MECKLENBURG COUNTY  
Park and Recreation Department

MEMORANDUM

**RE:** Rezoning Petition #2023-069  
PID# 19312102

**RZP-2023-069
 REZONING**

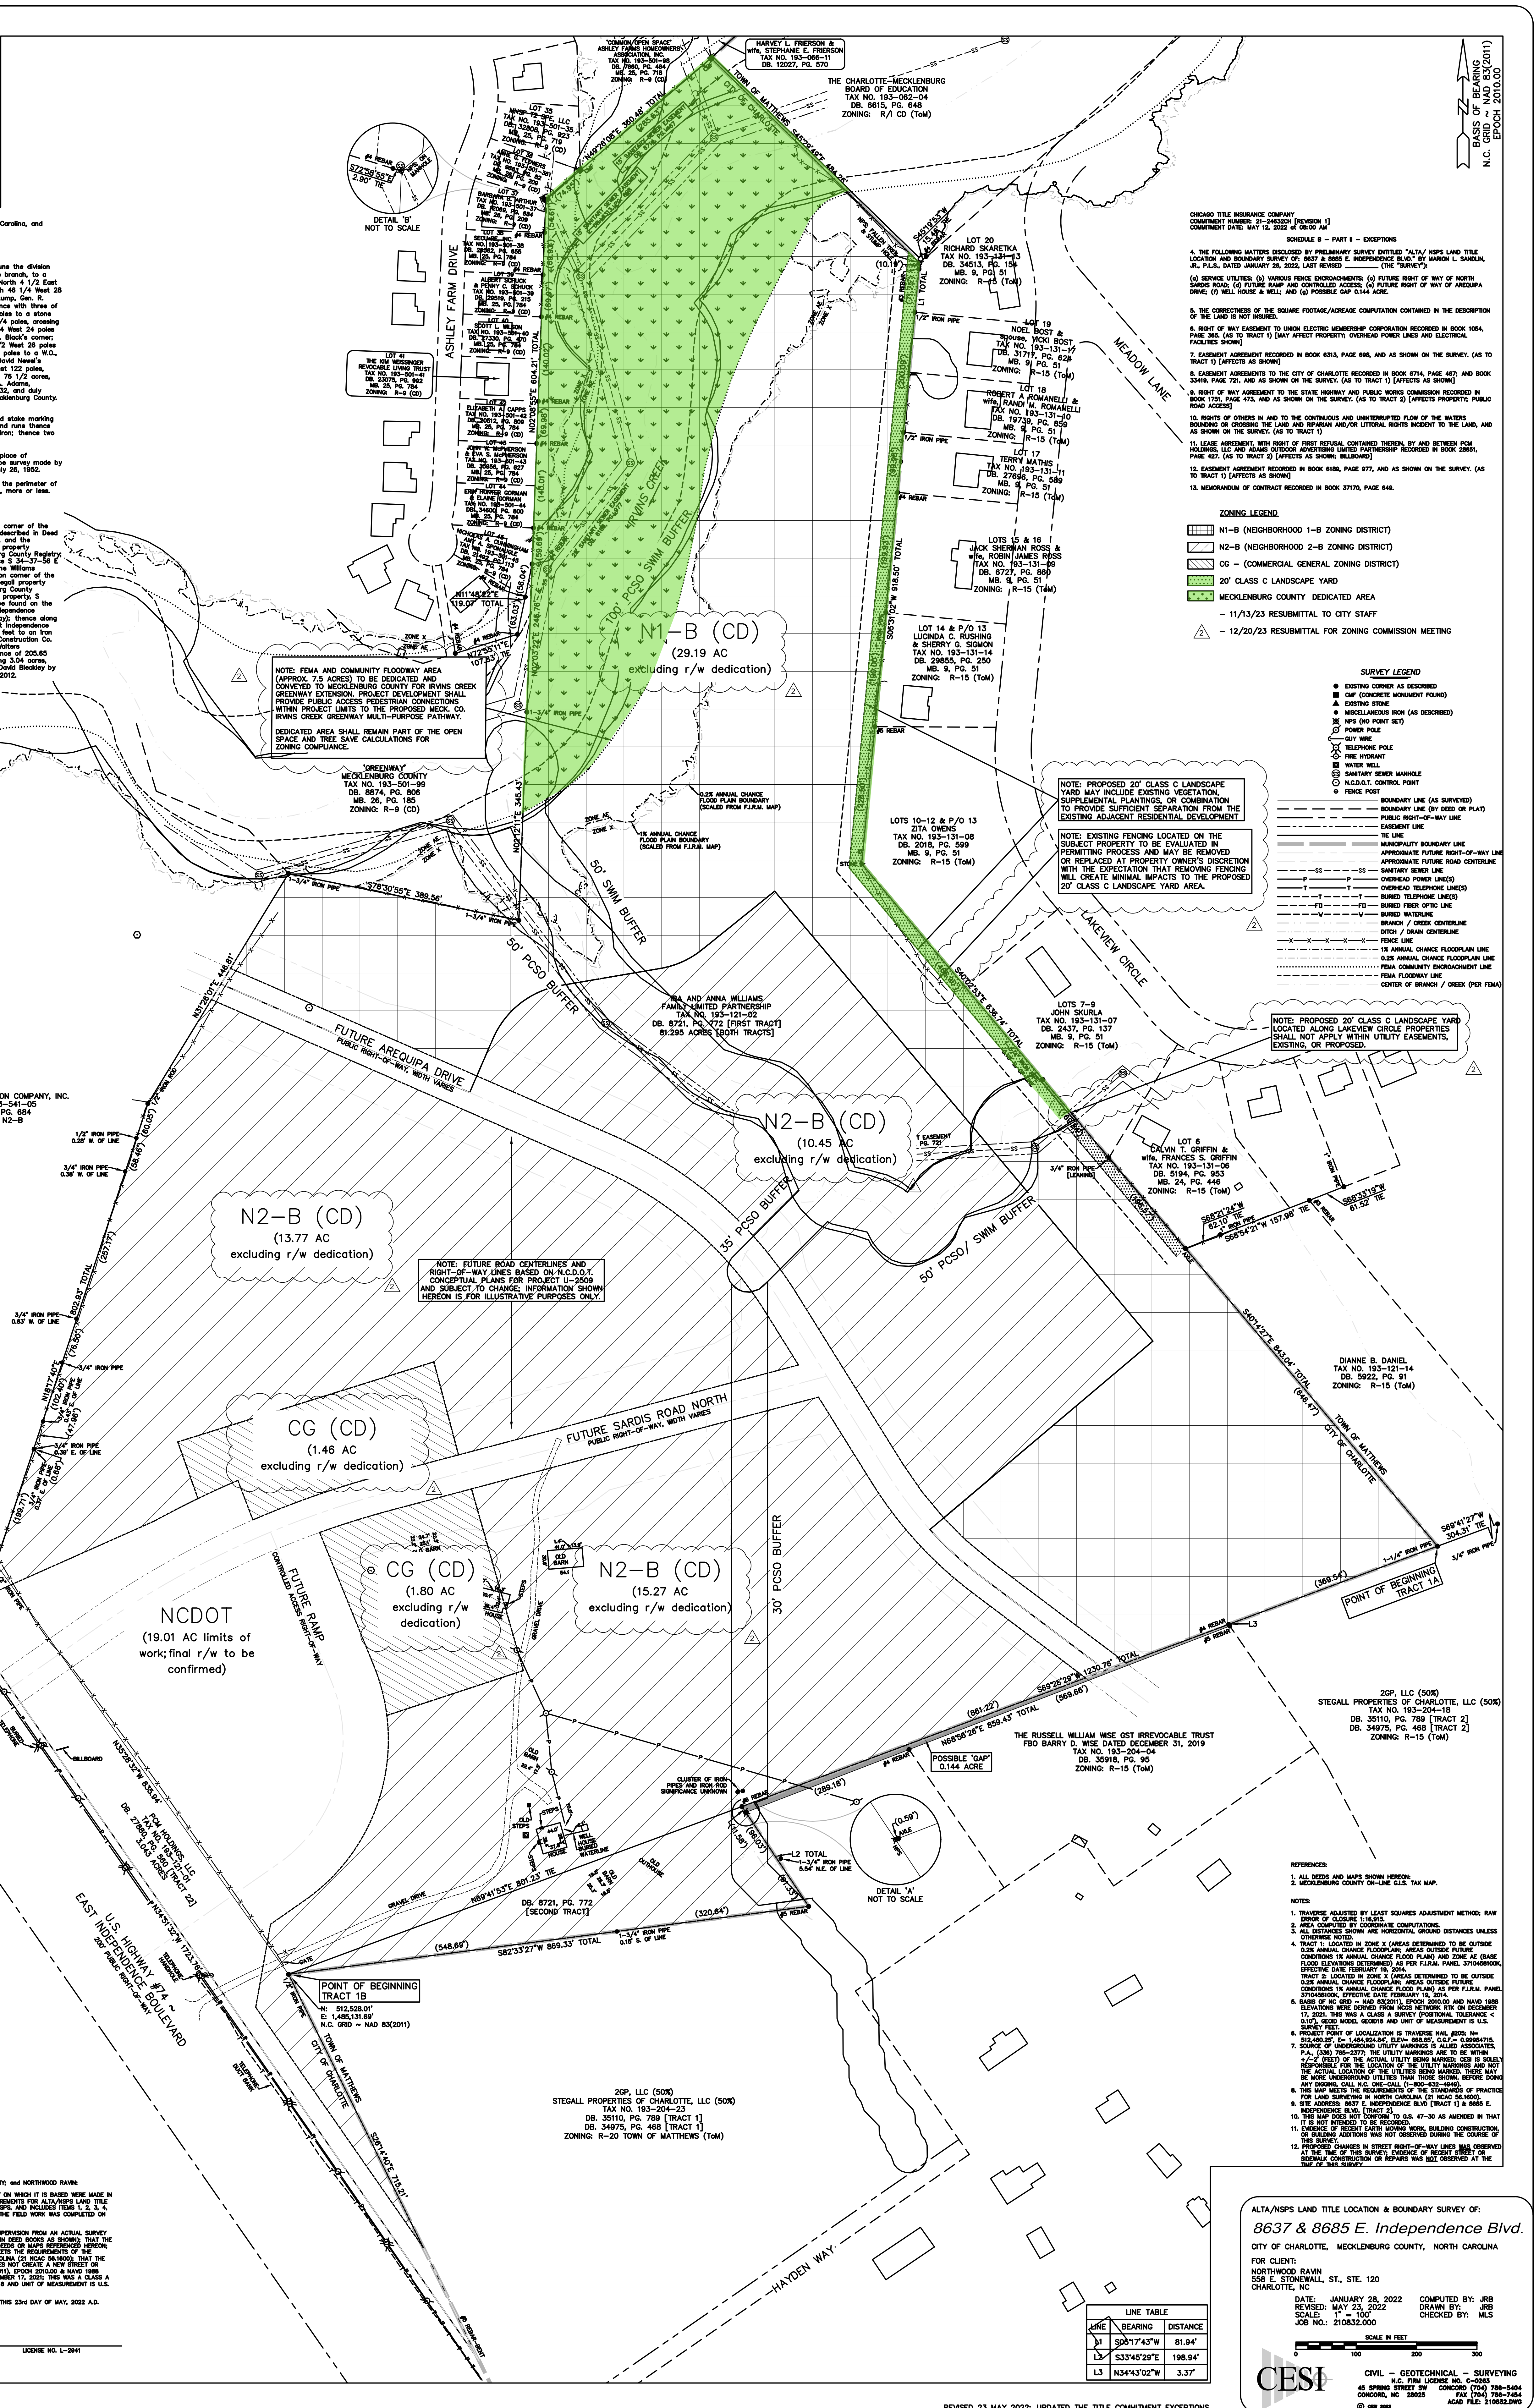
Based on the revised site plan we have the following comment: The dedication note should read: "to be dedicated and conveyed to Mecklenburg County for Irvins Creek Greenway..." Easements are conveyed to Mecklenburg County, not to the Park and Recreation Department. The creek is Irvins Creek, not Irwin Creek.
